Our ref: HA/2017/119481/01-L01
Your ref: A/99/17/OUT
Date: 21 June 2017

OUTLINE APPLICATION WITH SOME MATTERS RESERVED (ACCESS ONLY) FOR DEVELOPMENT UP TO 175NO. RESIDENTIAL DWELLINGS, PUBLIC OPEN SPACE, PLAY AREAS WITH ASSOCIATED INFRASTRUCTURE INCLUDING ROADS, DRAINAGE & LANDSCAPING. THIS APPLICATION AFFECTS THE CHARACTER & APPEARANCE OF ANGMERING CONSERVATION AREA & THE SETTING OF LISTED BUILDINGS. THIS APPLICATION IS A DEPARTURE FROM THE DEVELOPMENT PLAN LAND SOUTH OF WATER LANE, ANGMERING

Proposed Site Access Plan

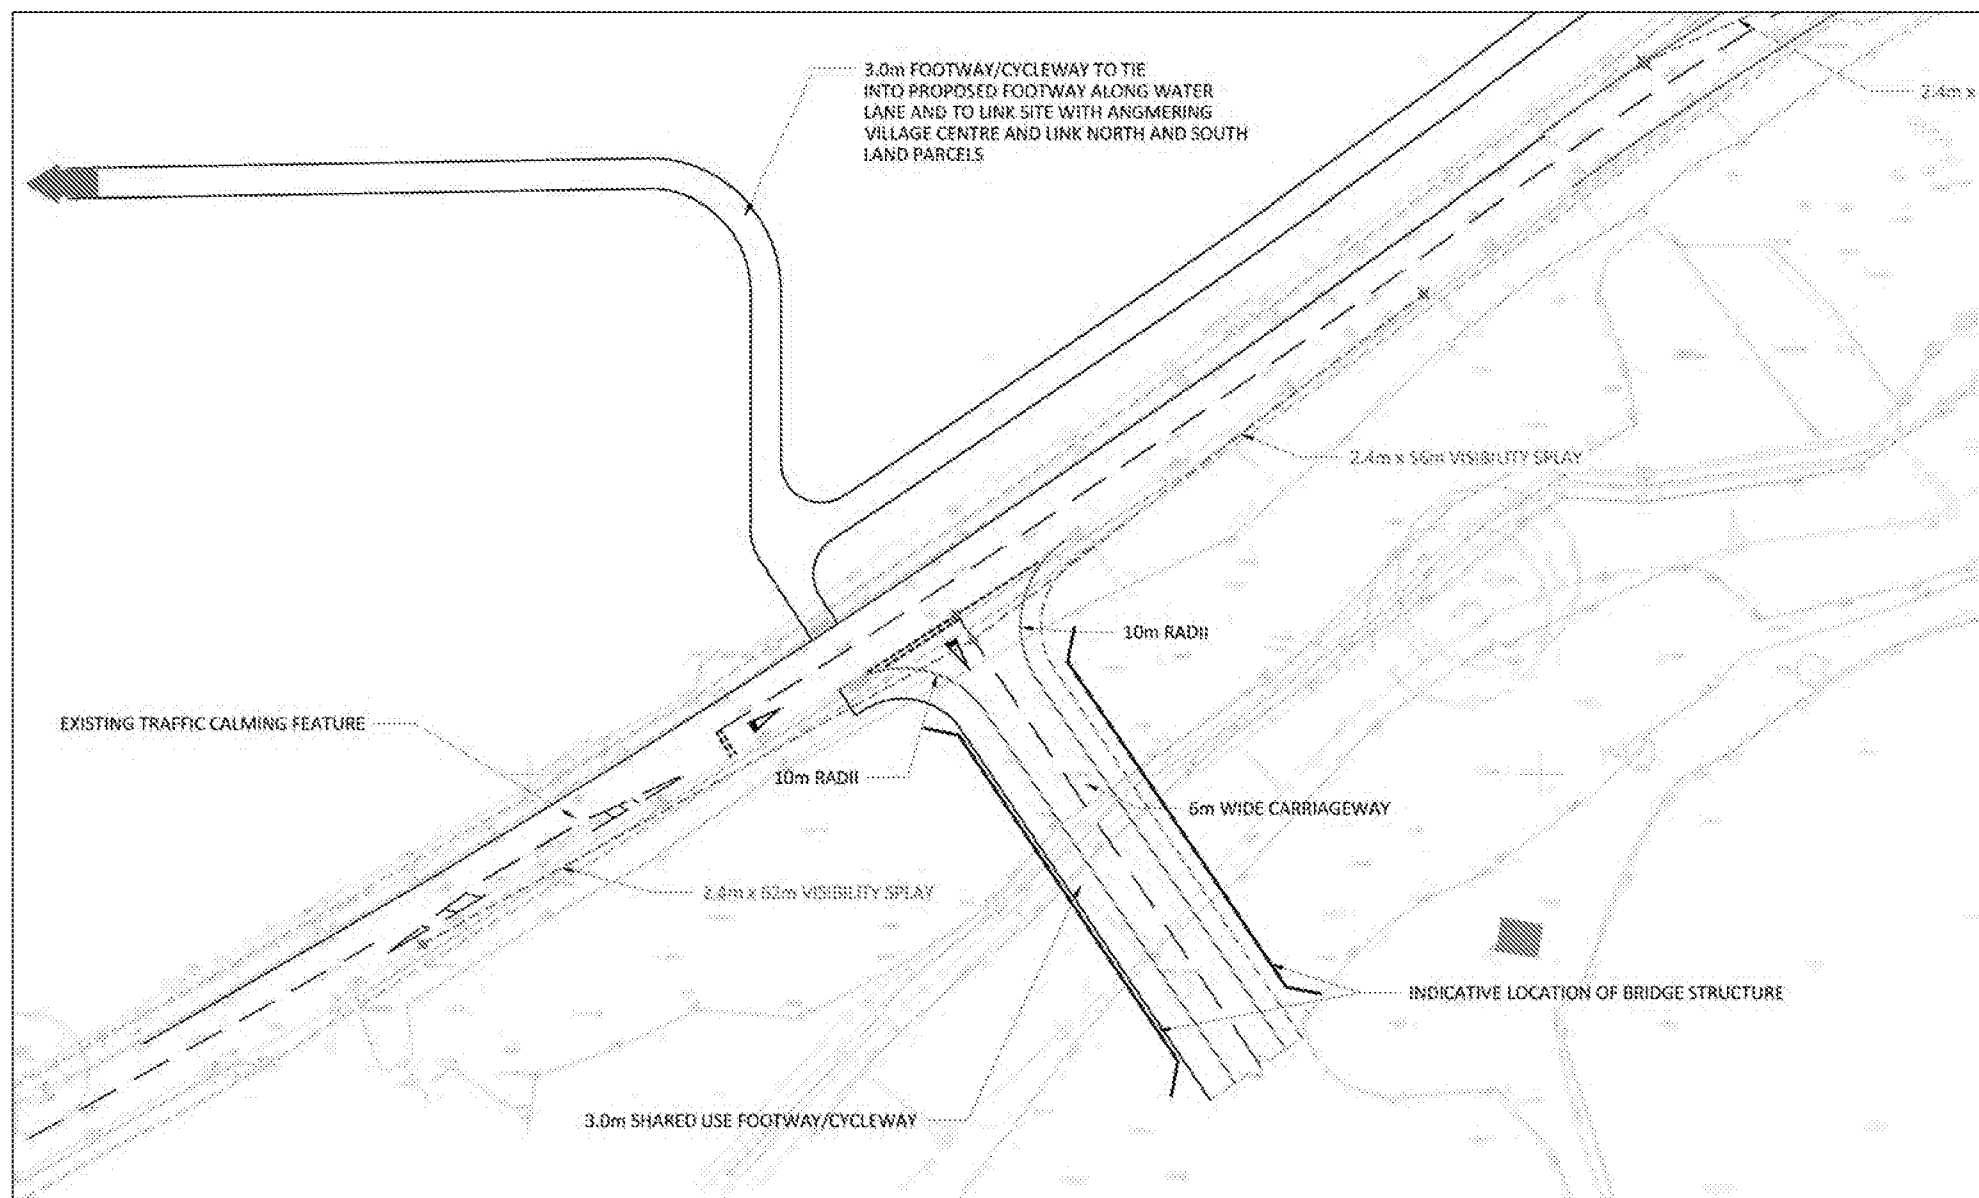
Additionally the proposed access route off Water Lane, adjacent Avenals Farm, will cross the Black Ditch, a classified 'main river' under the jurisdiction of the Environment Agency. Where any works in under or over the Black Ditch, or within 8metres from the watercourse bank edges, is proposed, an application for an Environment Permit (EPR) will be required.

In terms of any access road structure we will be looking for a clear span crossing. Again as part of the FRA it will need to be demonstrated whether the access route will result in any flood plain storage loss, and whether flood compensation will be needed. Due to the flood risk downstream in Angmering we would request as part of the proposal that additional compensation areas can be provided.
